Please ask for: Ms Iqraa Malik
Email: iqraa.malik@terraquest.co.uk
Telephone: 0121 234 1390
Our Ref: R/18/22/HH
Your Ref:
Date: 2nd February 2022

Application for Planning Permission for Works or Extension to a Dwelling

Development: Erection of single storey side and rear extension.
Location: 7 Evelyn Avenue Rustington BN16 2EJ

Drawing:
Plans and elevations as existing

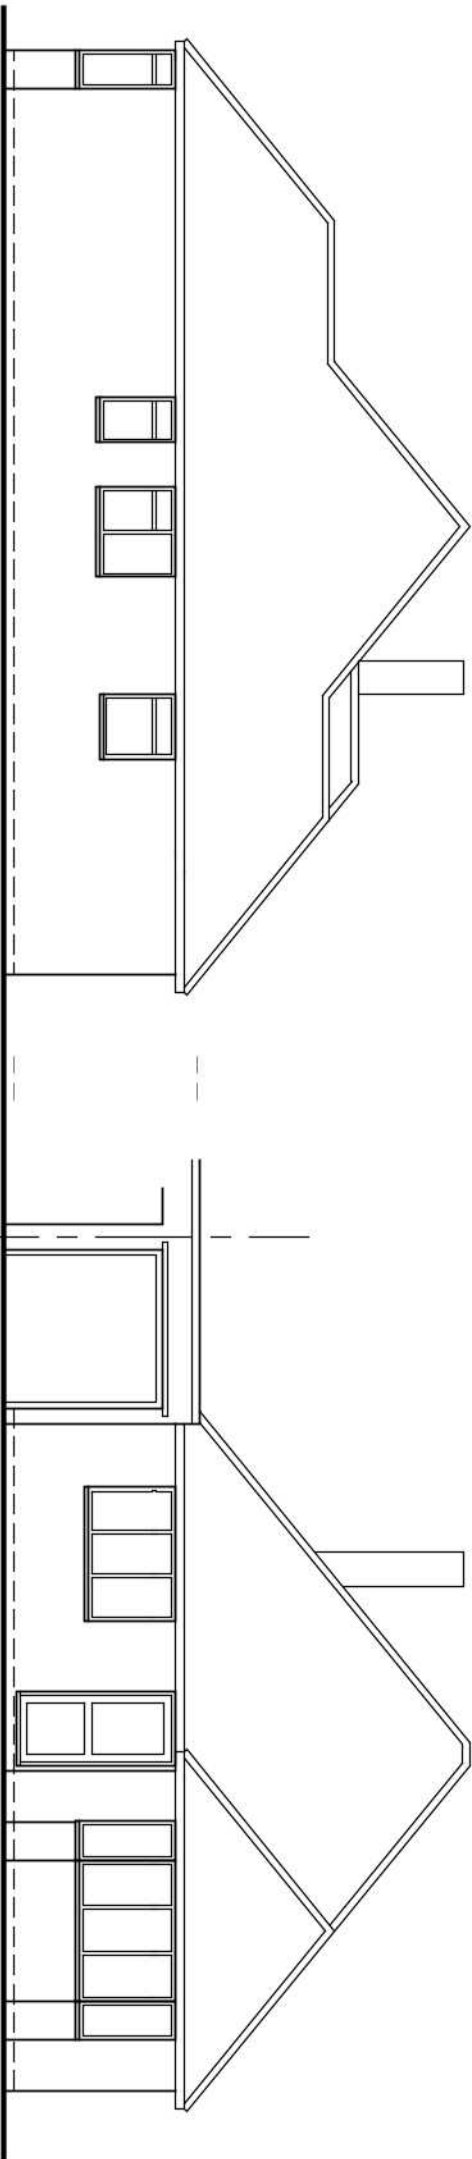
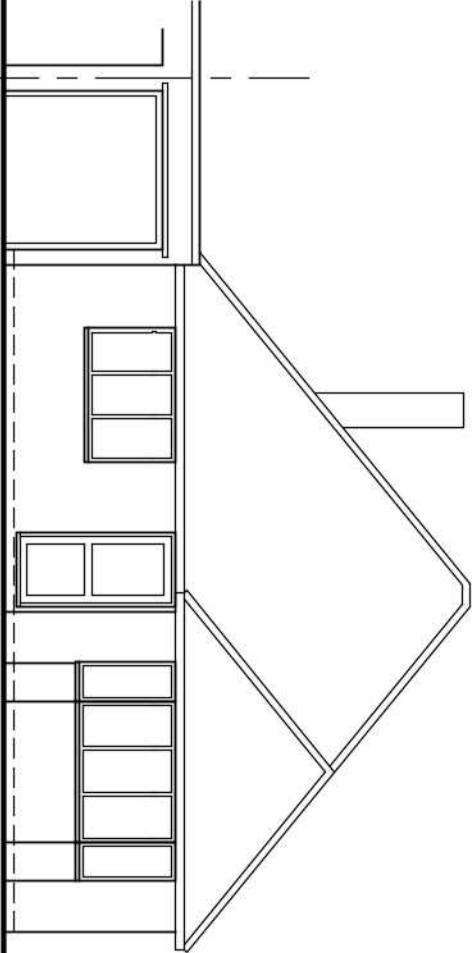
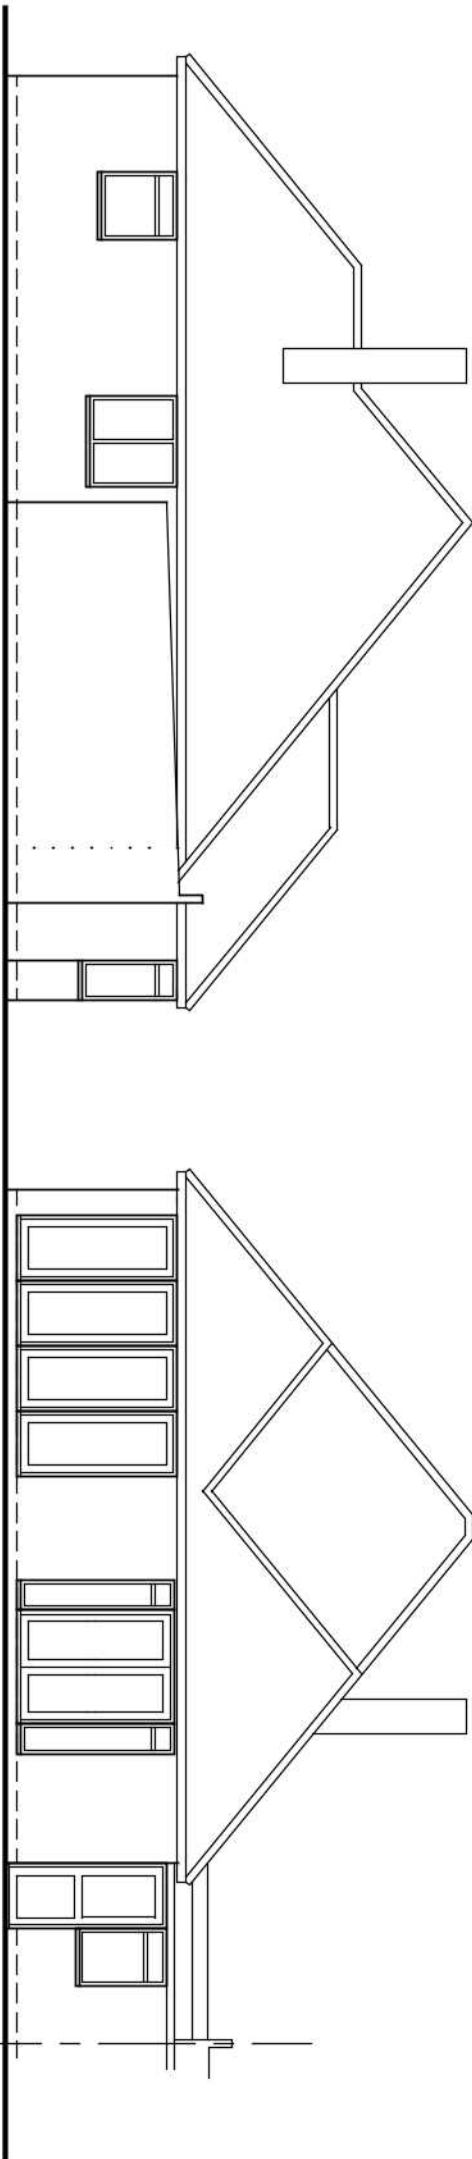
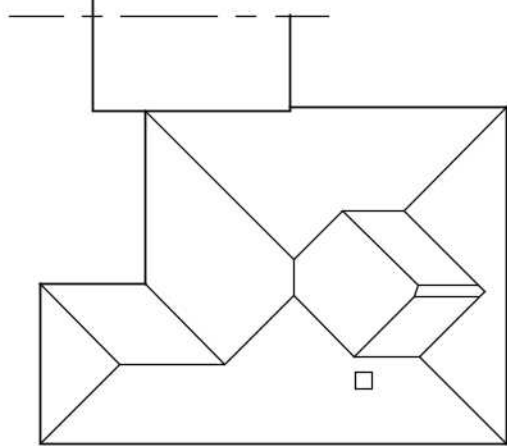
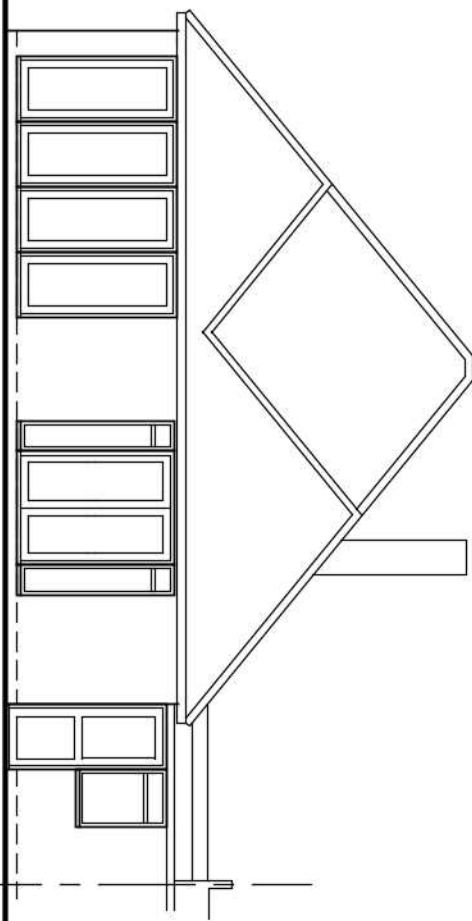
The existing rear elevation must also show the existing garage.
